From: Darryl Howells [REDACTED]
Sent: 28 October 2022 12:38
To: Maria Tomalova <Maria.Tomalova@arun.gov.uk>
Subject: FW: BN/65/22/PL

I have spoken with the architect re the representation from Portsmouth Water. He in turn has spoken with our Civil Engineer, our response is as follows:

Proposed Site Plan
1:200

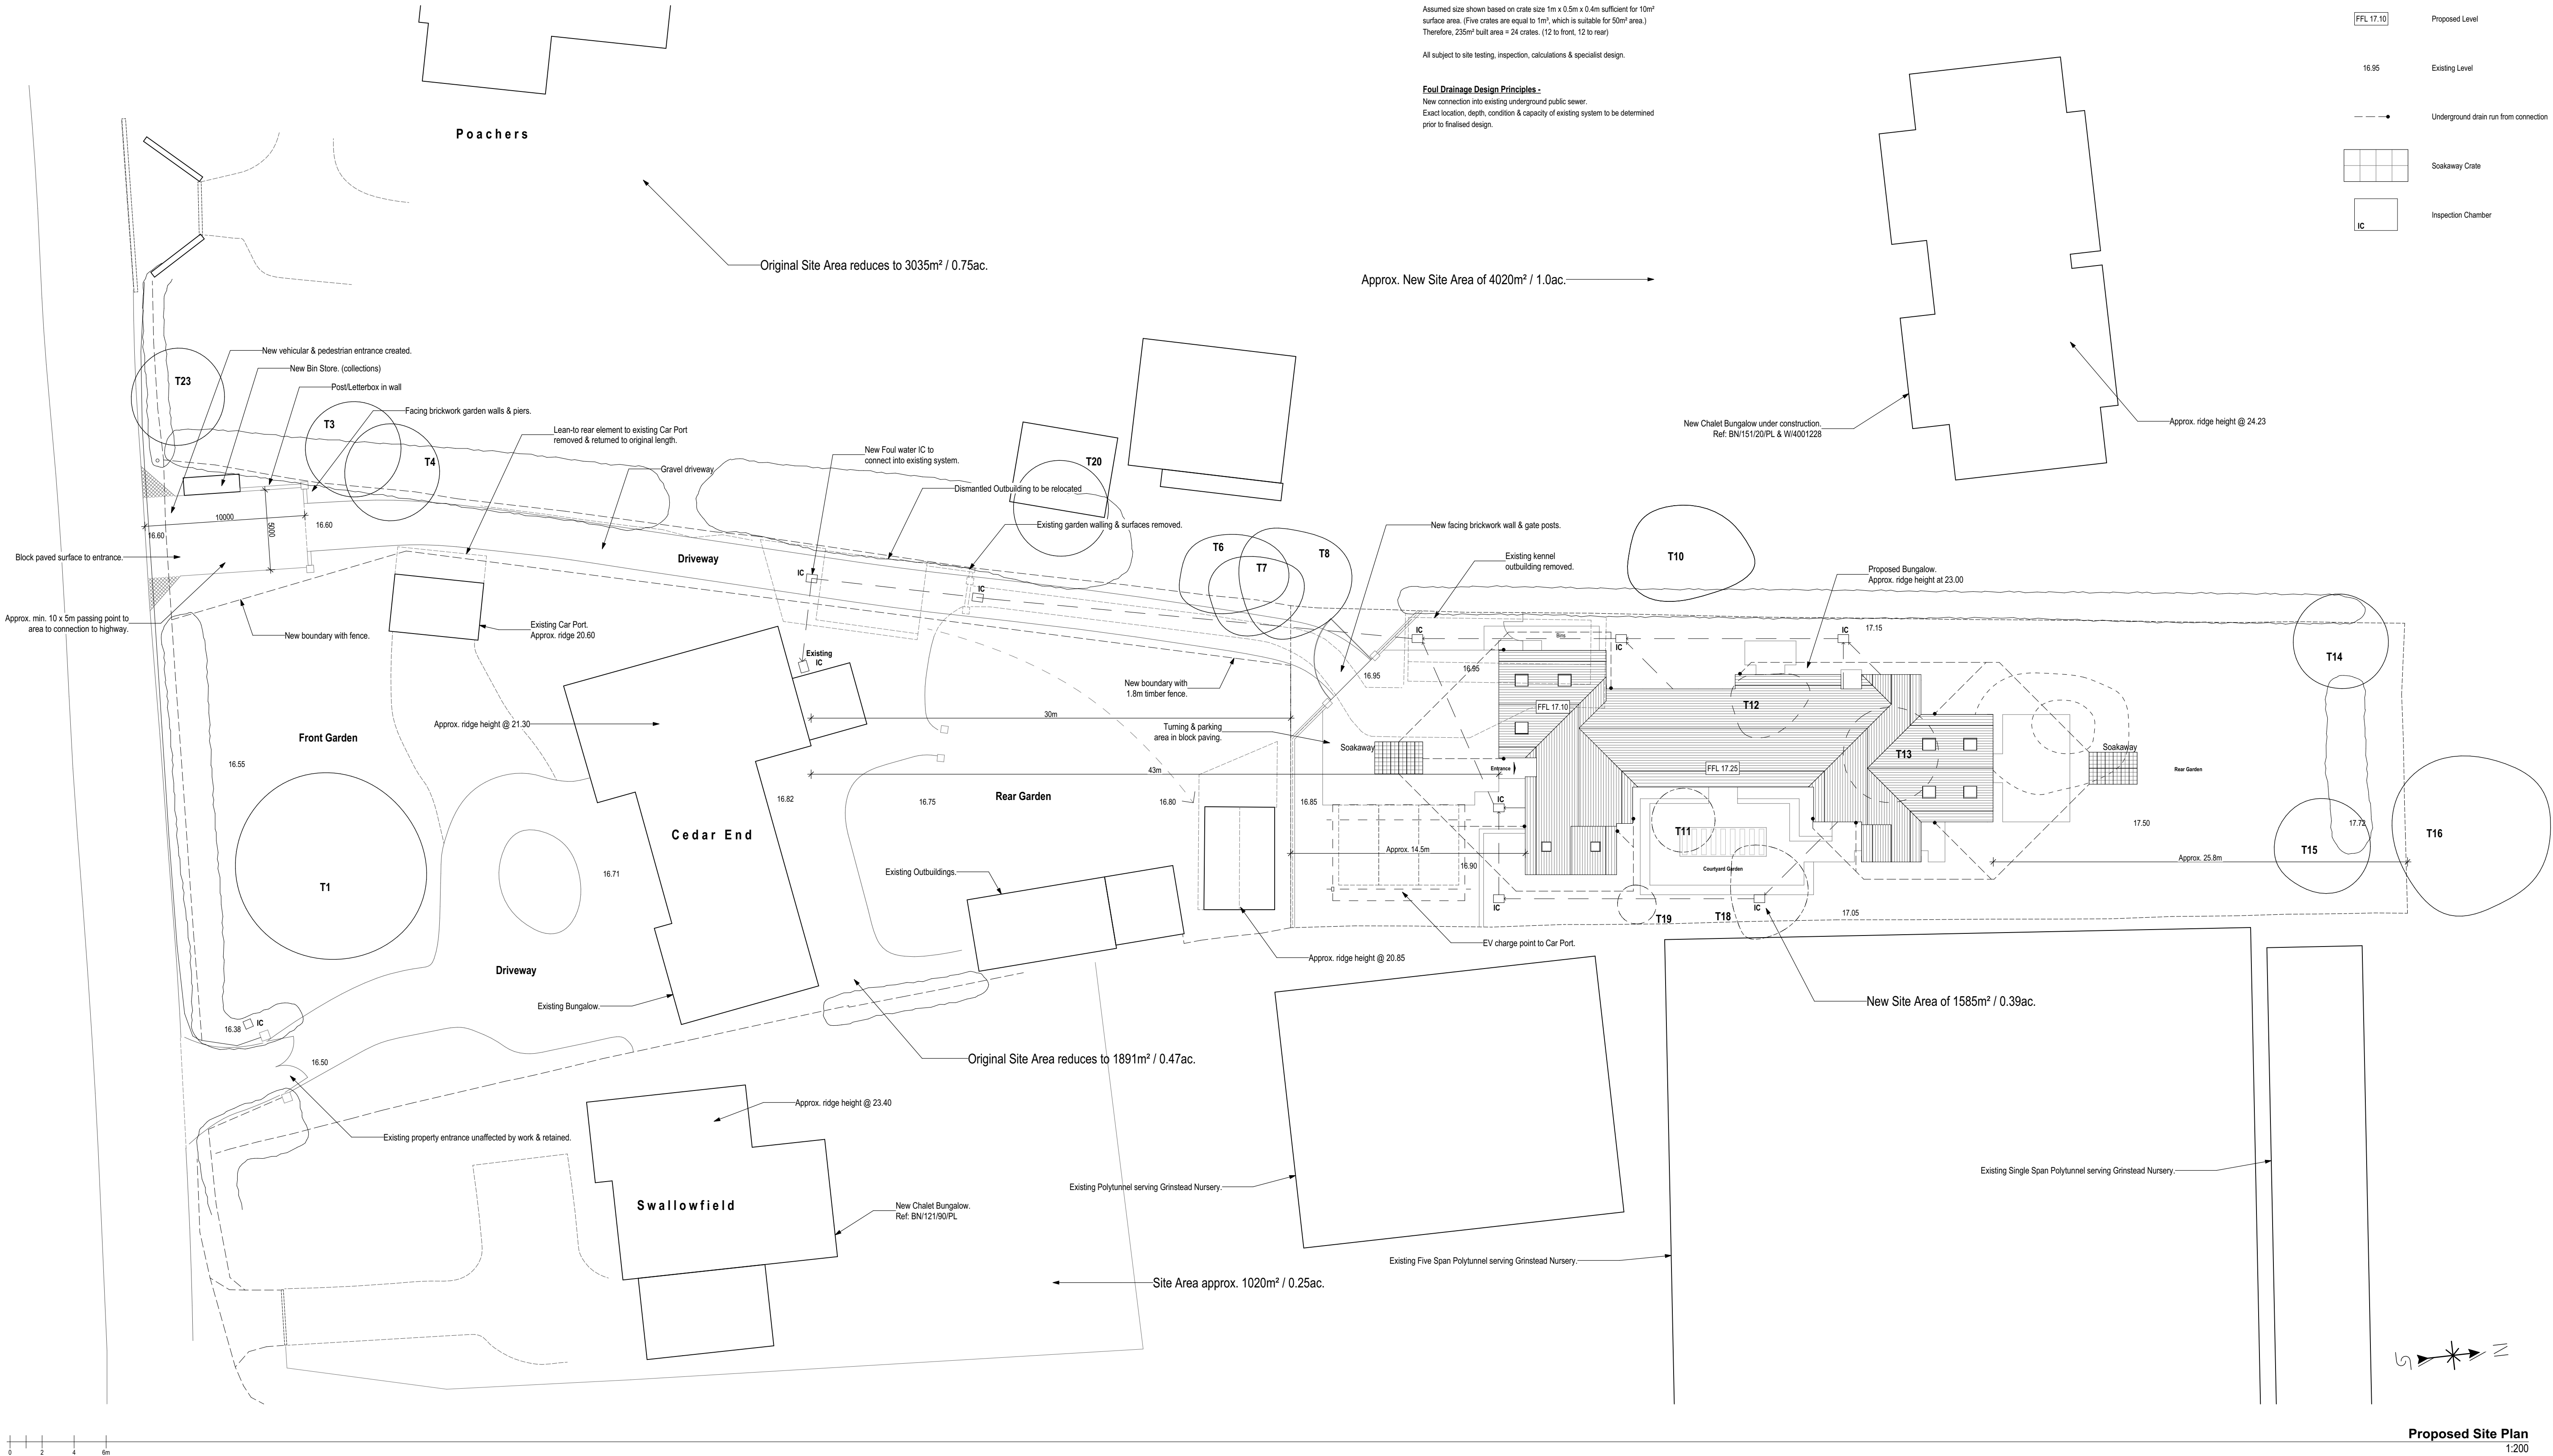
We note that the pollution hazard from roof water drainage is 'very low'. The proposed surface water drainage solution shows the principles & strategy, as opposed to finalised details. The inclusion of pre-filter silt trap is good practice & will be included if required & recommended by the Civil Engineer within the final solution. A geotextile membrane will surround the soakaway, therefore prevent soil or infiltration contamination. It is currently proposed for the driveway to be permeable/porous paving, to present no change to the current filtration/percolation of rainwater.

A detailed SUDS drainage solution will be calculated & proposed in compliance with all relevant regulatory controls, including British Standard BS8301 & BRE Digest 365. This will be based on site percolation tests & be to the Approval of the Building Control Authority.

A drainage management & maintenance plan, including pollution mitigation can be provided to satisfy any concerns and should be secured by planning condition.
